ISSUES		TOTAL NO. OF TIMES RAISED	COMMENT / RESPONSE
1. TRAFFIC			
1.1	The proposed car park does not adequately cater for the possible demand - not enough car parking is proposed. The marina will greatly affect the ability of residents or their visitors to access visitor parking especially during peak times of marina operations. The car park design fails to provide essential facilities i.e. storage areas/loading areas.	82	Council's parking requirements for marinas are 0.6 spaces per wet berth, 0.2 spaces per dry berth or swing mooring and 0.5 spaces per employee. This compares to AS 3962 - 2001 which requires 0.3 to 0.6 spaces per wet berth, 0.2 to 0.4 spaces per dry berth, 0.3 to 0.6 spaces per swing mooring and 0.5 spaces per employee, plus one space per 30m2 for ancillary activities not related to boat berthing. AS 3962 - 2001 notes that 0.6 spaces per wet berth should be considered for racing clubs, and 0.3 for commercial facilities such as the proposed development. Council's parking requirement is therefore not considered to be appropriate as the proposed development is not a racing club marina. The proposed 58 space car park satisfies the Australian Standard and is therefore

BED TREATMENT

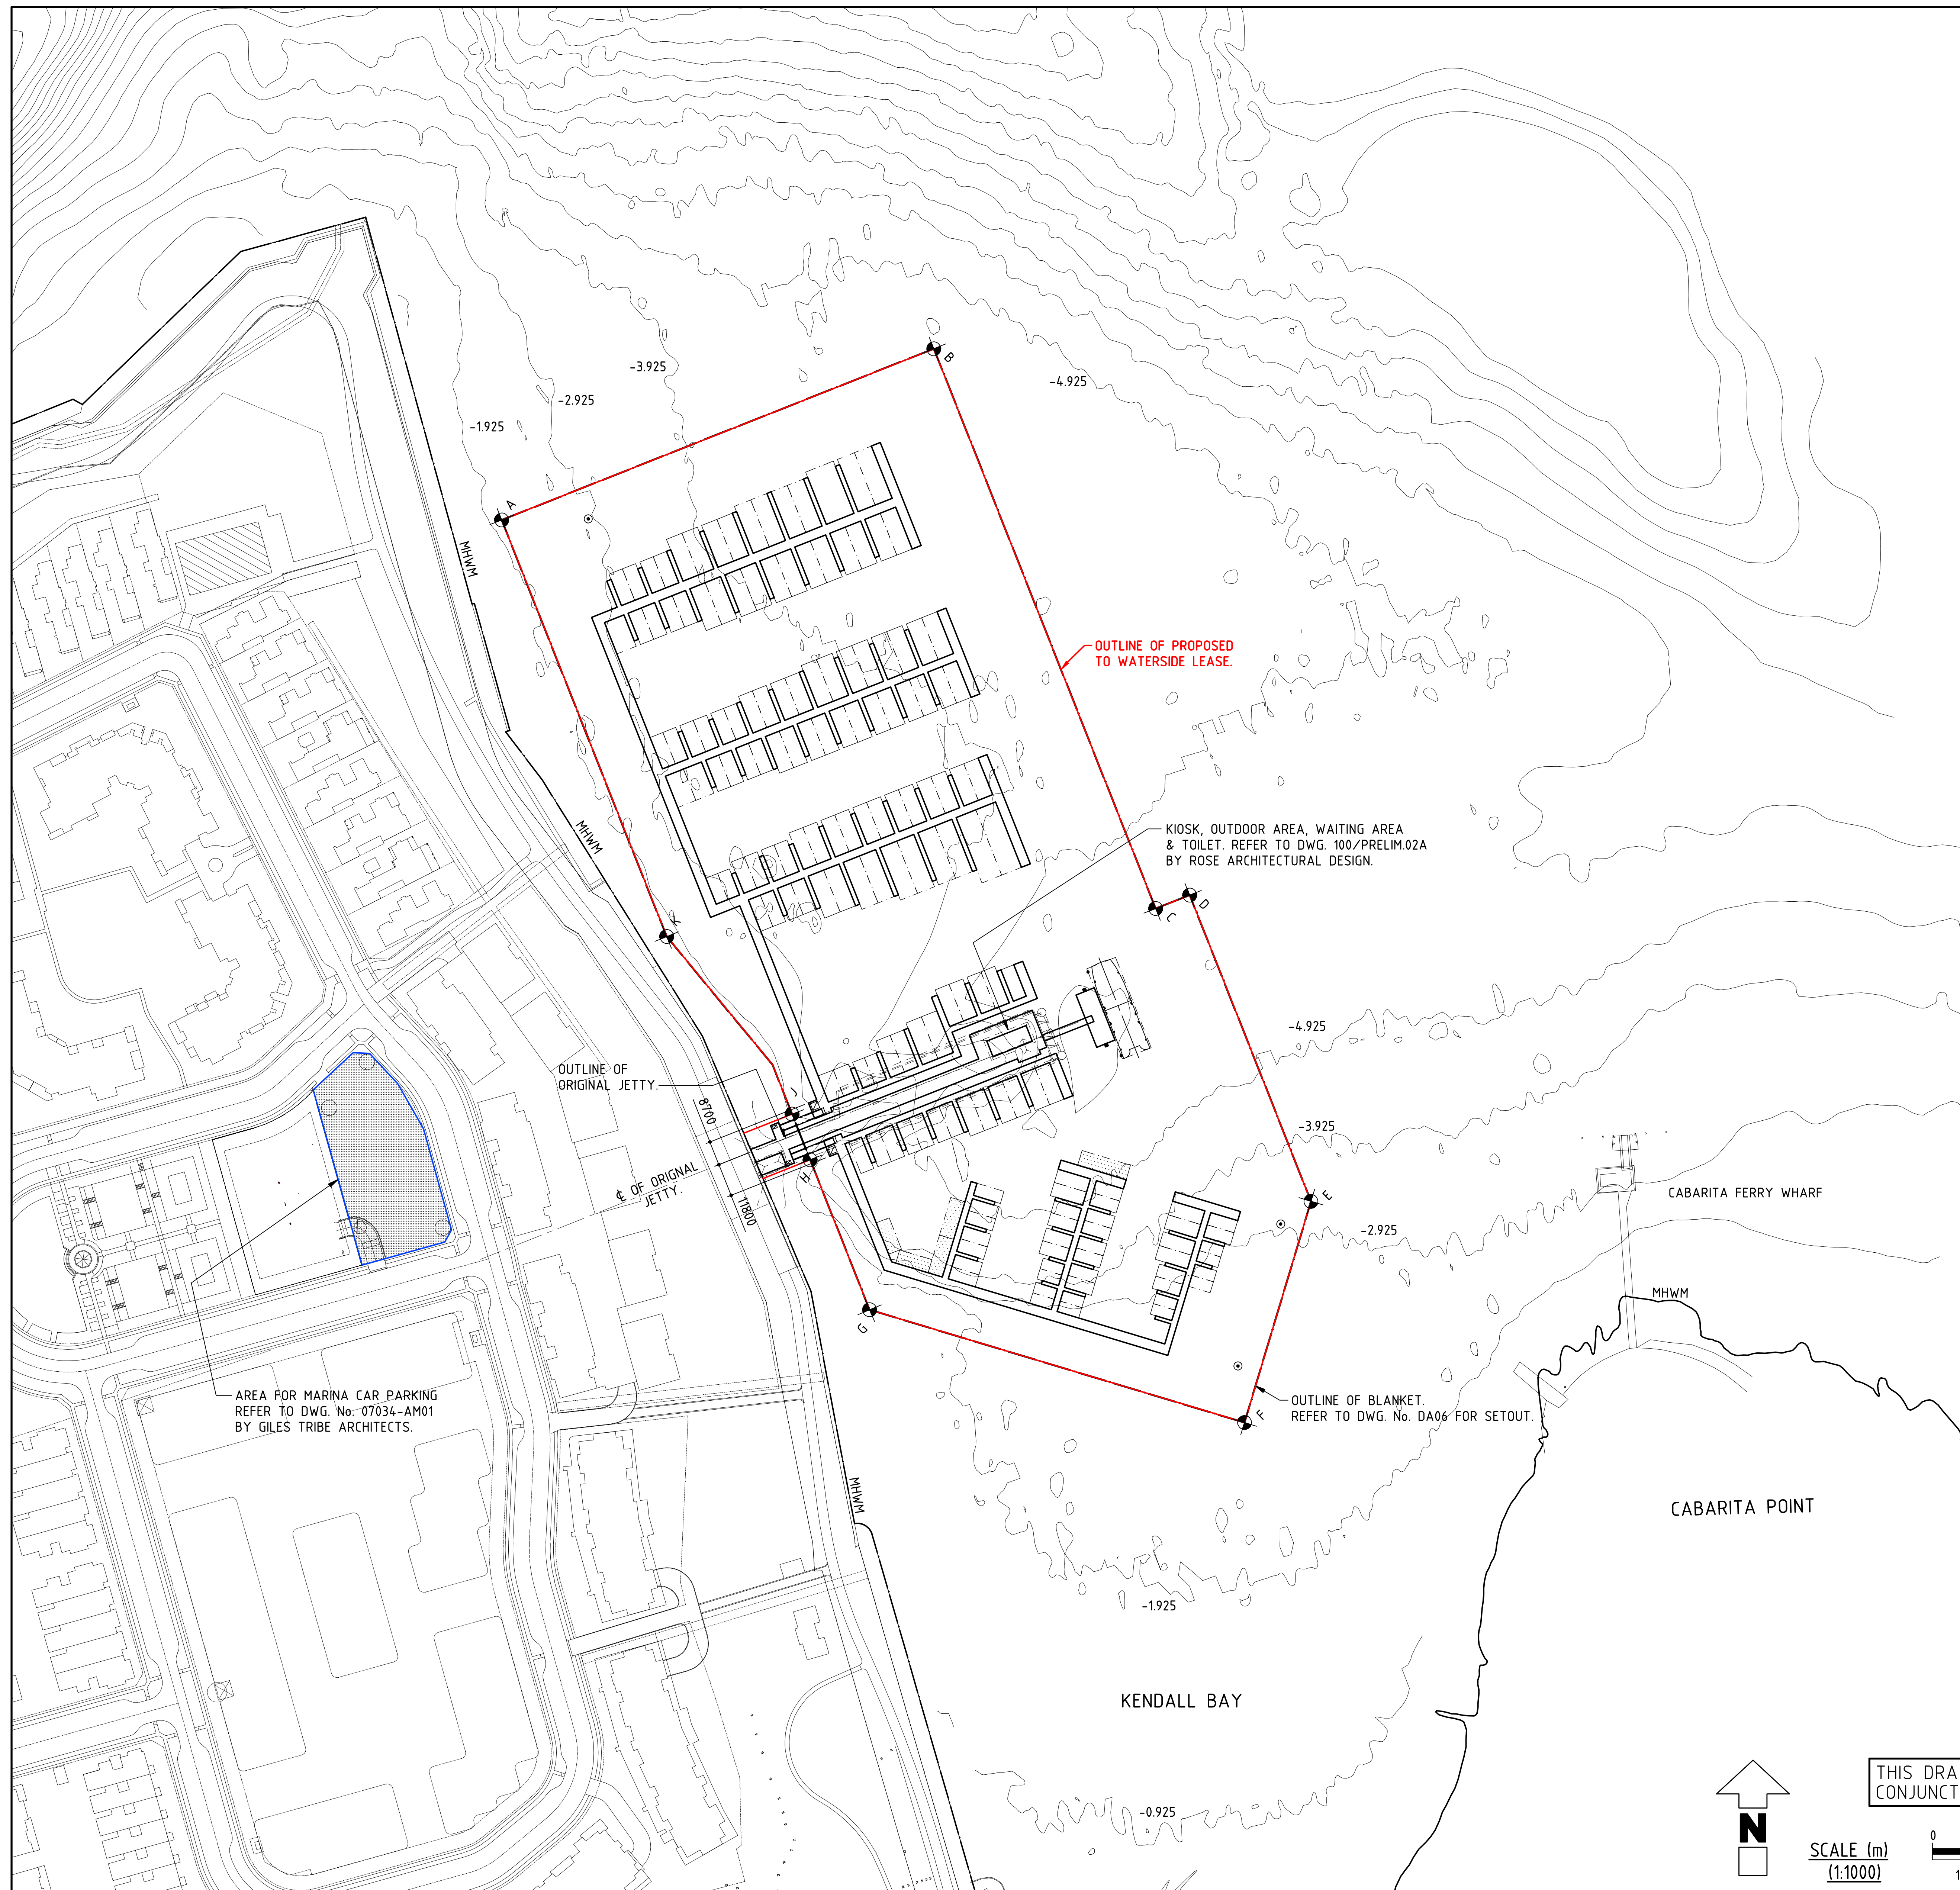
2.2	The proposed geotextile blanket does not meet the requirements of the remediation order issued by the EPA.	59	The requirements of the Remediation Order are being addressed as part of the Environmental Assessment. The proposed remediation method (geotextile blanket) has been discussed with the Department of Environment, Climate Change and Water (DECCW). DECCW have provided their comments in letter dated 30 November 2010. The proponent has reviewed this letter and has prepared a response (refer to Response to Agencies' submissions table).

2.8	The proposed geotextile blanket has no proven track record. The unknowns of utilising the proposed matting under a commercial marina.	83	<p>Geotextiles of the type proposed are used widely in coastal engineering applications (refer to Port of Brisbane Case Study, Nerang River and San Diego Bay contained in Attachment 4 to the Response to Agencies' submissions (23/02/11)).</p> <p>The proposed geotextile Elcomax 1200R is the heaviest grade non-woven product which is available. Refer to Appendix 1 - Summary of Agencies' Submissions and Proponent's Responses - Attachment 4 for further detail. The geotextile will readily accommodate the puncture (drop cone) and tear loads (wide strip tensile strength) than could be associated with the construction and operation of the marina.</p> <p>The capacity of the geotextile materials to withstand the contaminants within the sediments of Kendall Bay has been assessed Dr John Scheirs (Refer to Appendix 1 - Summary of Agencies' Submissions and Proponent's Responses - Attachment 4 for further detail.) The geotextile was found to be resistant to the PAHs TPH present in the sediments, microbial and biological attack, will not be degraded by hydrolysis as water temperatures in Sydney Harbour are less than 35 degrees and that there are no levels of phenols present to significantly impact on the durability of the lifespan of the geofabric.</p> <p>Appendix 1 - Summary of Agencies' Submissions and Proponent's Responses - Attachment 4 demonstrates that the geotextile has been used in revetments and break waters where the wave energy is significantly higher than at Kendall Bay. In these situations the rocks placed on the geotextile are significantly larger than will be used in the ballast for the marina project for example the reclamation project at the mouth of the Brisbane River. There risk of accidental tearing of the geotextile has been greater in these projects than for the proposed marina. Testing of the geotextile has been undertaken specifically for the Brisbane River project. No tearing of the geotextile occurred.</p>

2.17	The modification of the sea bed bathymetry by the proposed geotextile blanket and ballast. This encroachment on the sea bed is effectively reclamation of 5.6 ha of the waterway. The mat will be damaged by vessels using this location.	8	<p>The SPS will not be damaged by vessels using this location and has been designed to withstand all hydrodynamic loads, namely tides, tidal currents, wind induced circulations, flood flows, wind waves, boat waves, propeller wash, and stormwater outlet flows.</p> <p>There will be clear water between the keel and propellers of the vessels and the blanket at all stages of the tide. The ballast has been specified to withstand the propeller water jet effects and the wind and vessel wave effects at the site.</p>

2.29	The slope of the floor of Kendall Bay often exceeds the USA recommended maximum grad (risk of sliding). The SPS in all DA drawings is offset by 10-20 metres from MHWM. Failure of proposed silt curtain due to irregular SPS Basalt surface & sloping floor. The GBAC predicted currents greatly exceed the USA recommended threshold current of 0.5m/sec when silt curtains become ineffective. The 70m wide openable gate in the silt curtain will allow contaminated sediments to escape during out flowing tides. Withdrawal of temporary piles will lift/suck up contaminated sediments into the water above. There has been no engineering risk	1	The procedure for assessing down slope migration in PIANC (1987) is independent of slope. This makes no sense if the substrate is flat. GBAC can only presume that the procedure pertains to "revetments" in line with the title of the text which typically are sloped at 1:1.5 to 1:3 (v:h). The steepest bed slopes under the SPS are 1:5 (v:h). The typical bed slopes are flatter than 1:15. GBAC would not expect down slope migration of the SPS to be an issue although this should be checked by a geotechnical engineer. Currents at the silt curtain during marina construction would generally not be expected to exceed 0.3 m/s. Max ebb currents up to 0.7 m/s are encountered in the main channel, towards the northern margins of the Remediation Site but not in Kendall Bay where tidal velocities would not be expected to exceed 0.2- 0.3 m/s (URS, 2006). GBAC would not expect peak tidal velocities to exceed 0.5 m/s at the NE corner of the outer silt curtain which is the most exposed point. Based on turbidity monitoring of propeller wash in Kendall Bay (2007), GBAC has assessed that marina operations should not increase background turbidity in the bay by more than 1 NTU (GBAC report, Appendix C).
